Your ref:
Our ref: 21/02363/F
Please ask for: Mr Steve Fitzgerald
Direct dial: 01553 616218
Direct fax: 01553 616652
E-mail: borough.planning@west-norfolk.gov.uk

TOWN AND COUNTRY PLANNING ACT 1990

Details: **Rebuilding of original Carrstone wall in connection with planning application 20/00303/FM. at Deerfields Lynn Road Setchey KINGS LYNN Norfolk**

STREET SCENE
SCALE 1:50

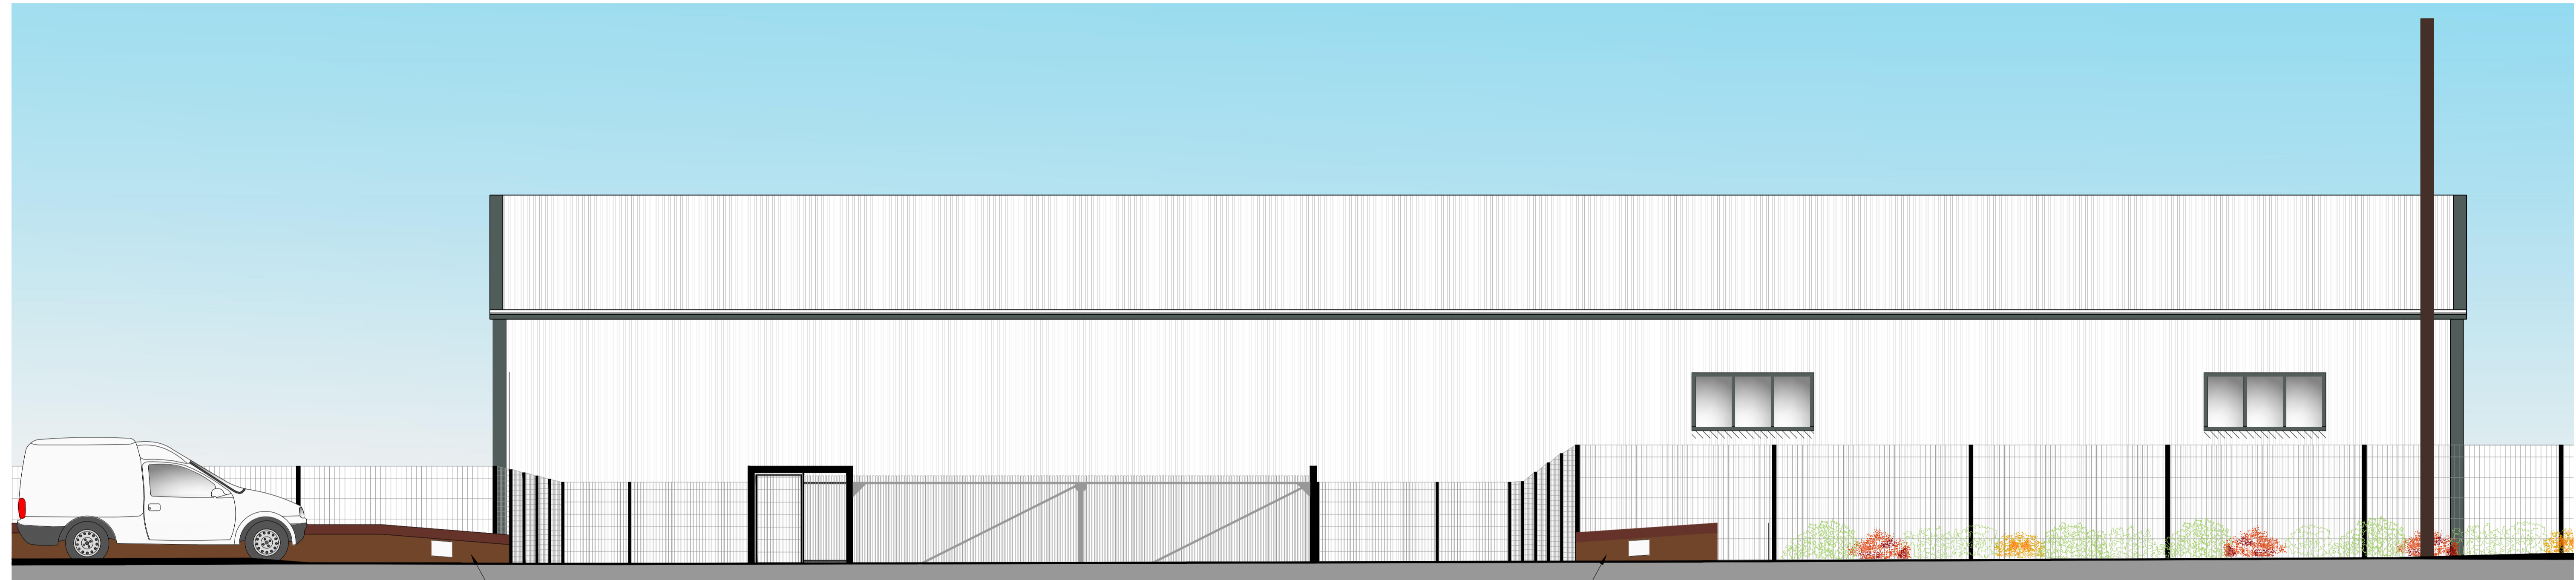
1. Please provide an indicative elevation drawing of a portion of the wall to a scale of 1:100 or 1:50.
